**Application by Port of Tilbury London Limited for an Order Granting Development Consent for a Proposed Port Terminal at the Former Tilbury Power Station ('Tilbury2')**

**The Examining Authority's second written questions and requests for information (FWQs)**

**Issued on 8 May 2018.**

## TRAFFIC REGULATION MEASURES PLAN

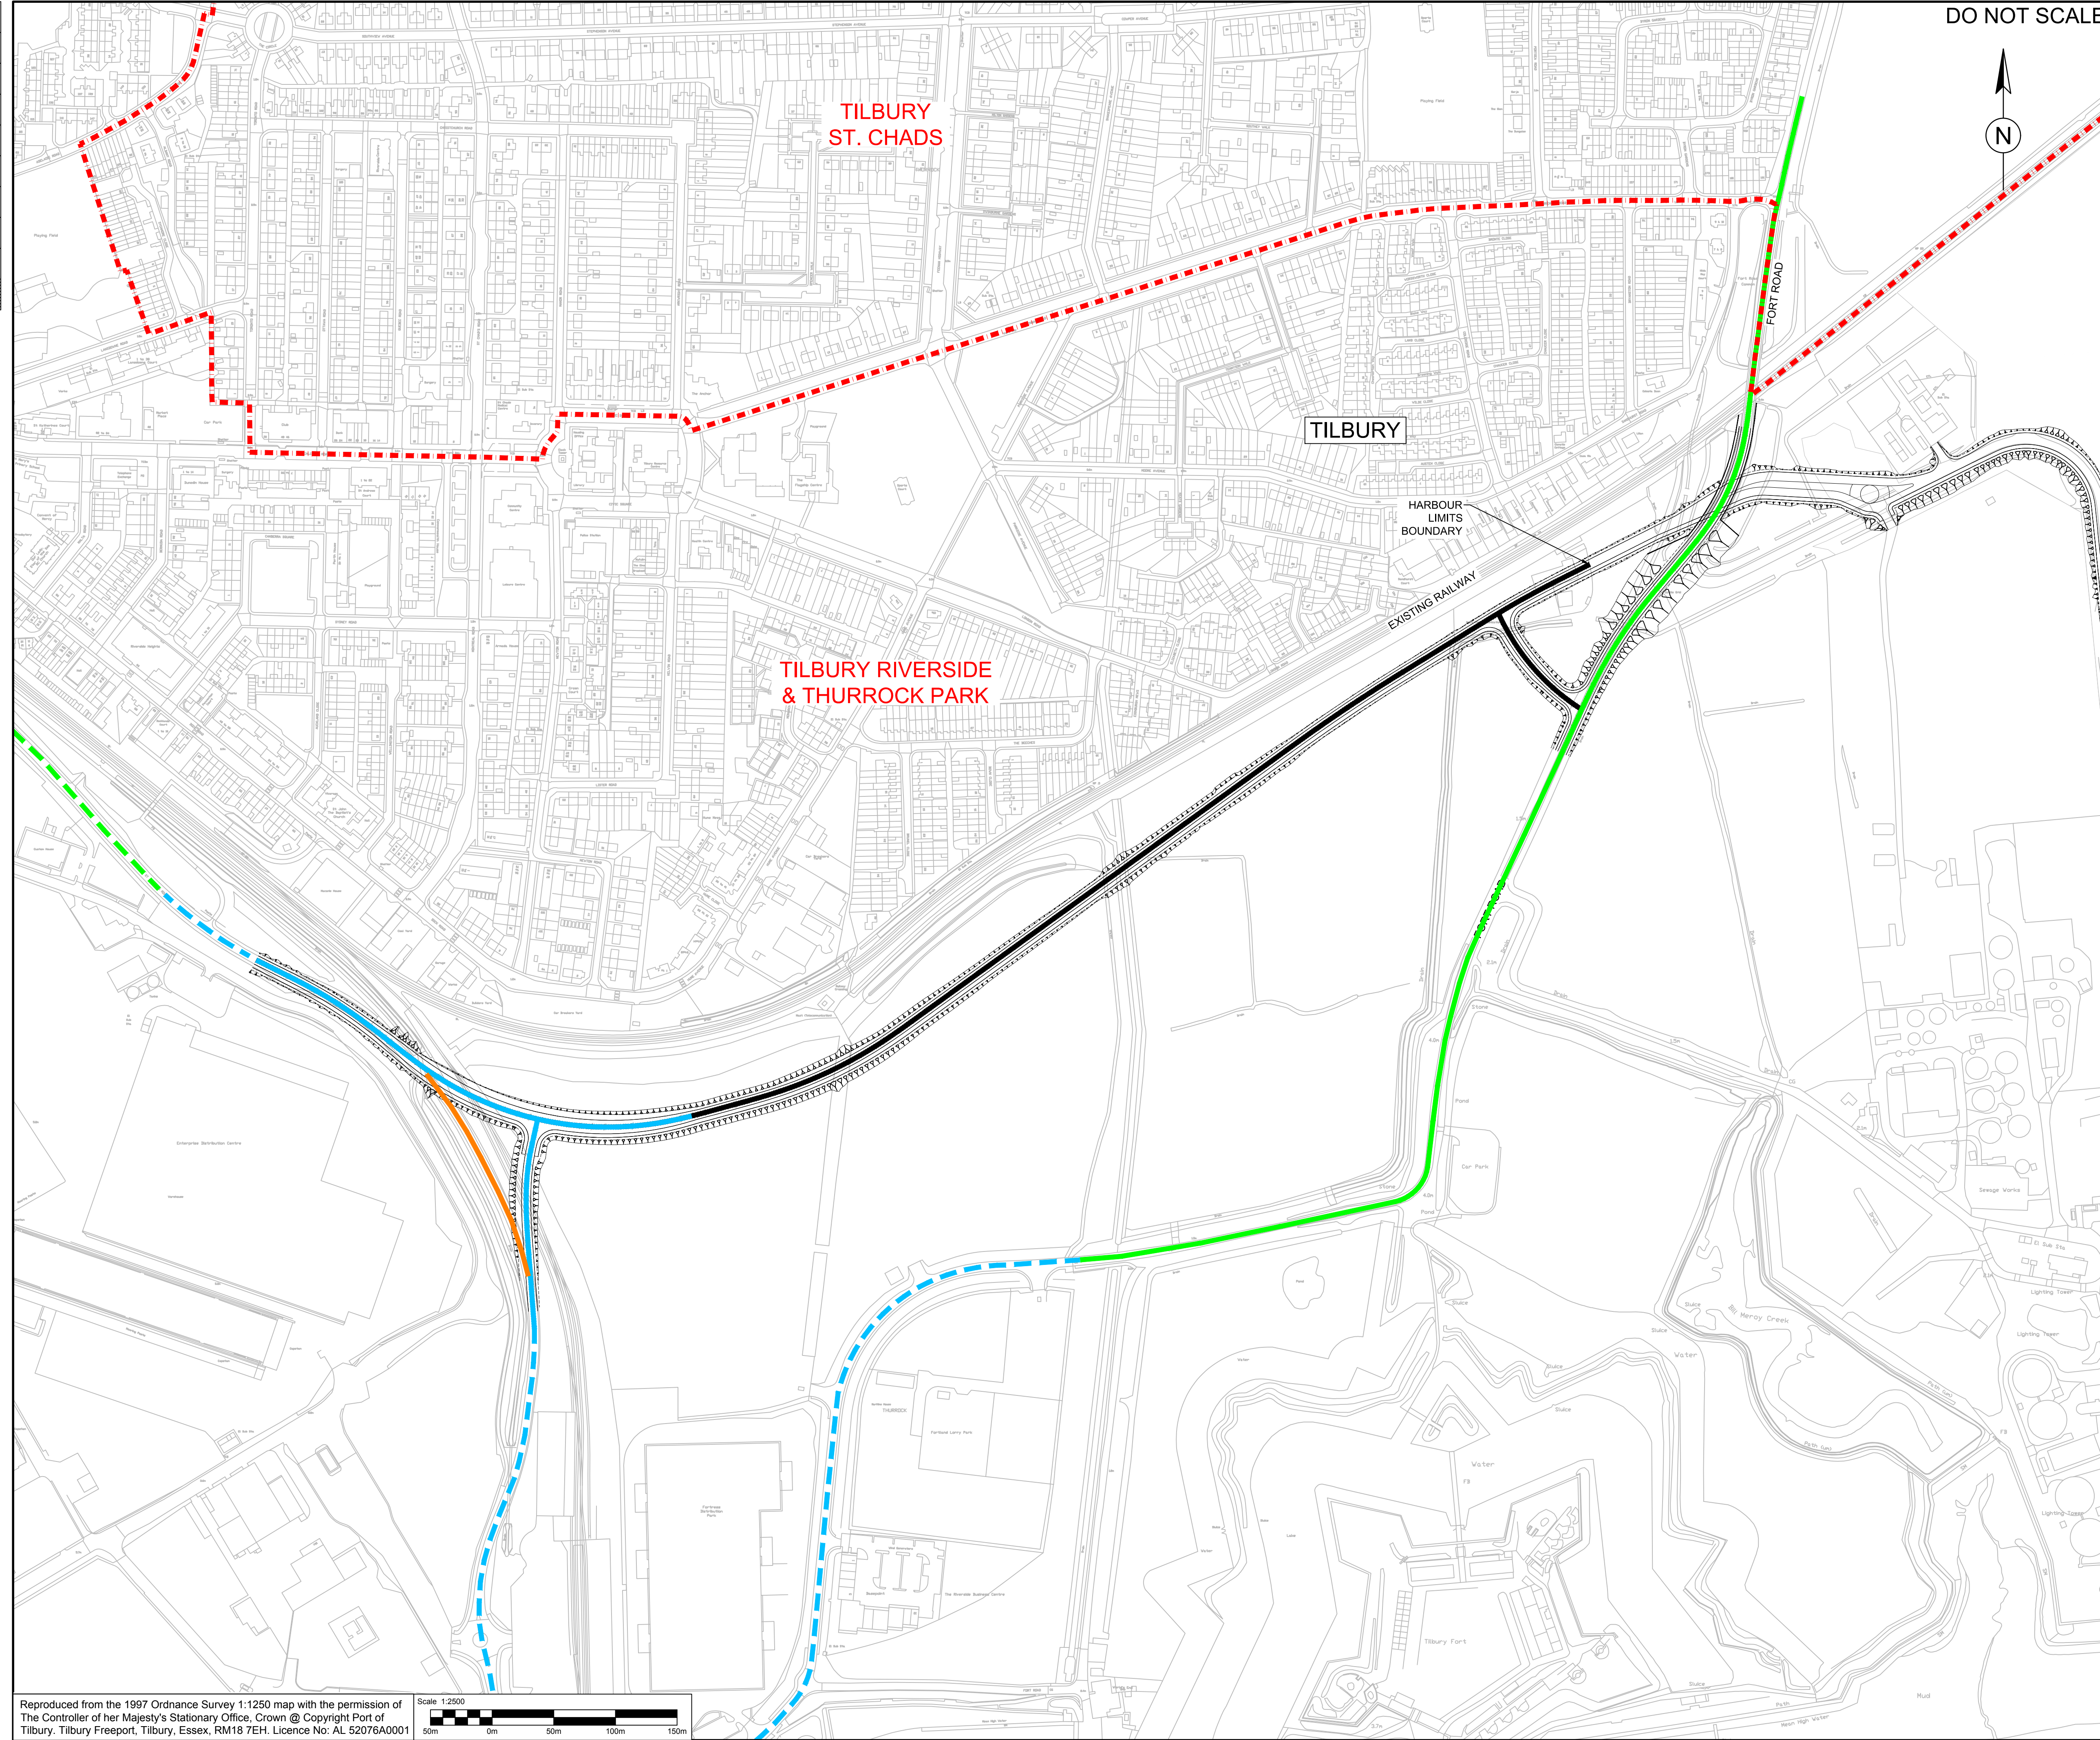
2.8.46	Applicant, Thurrock Council (TC), Highways England (HE)	<p><i>Schedule 8: Traffic Regulation Measures, etc.</i> The Applicant states, in the summary of the case made at the DCO hearing on 21 February 2018 [REP1-015], that TC was not entirely content with Schedule 8 as drafted, and that HE</p>

SWQ	Question to:	Question:
		<p>stated that some traffic regulation measures would need to be changed in relation to the Asda roundabout.</p> <ul style="list-style-type: none"> <li>i. Would the Applicant, TC and HE update the Examination on the status of their discussions on Schedule 8?</li> <li>ii. Delete "speed limit to be imposed" from each entry in column 2.</li> </ul>
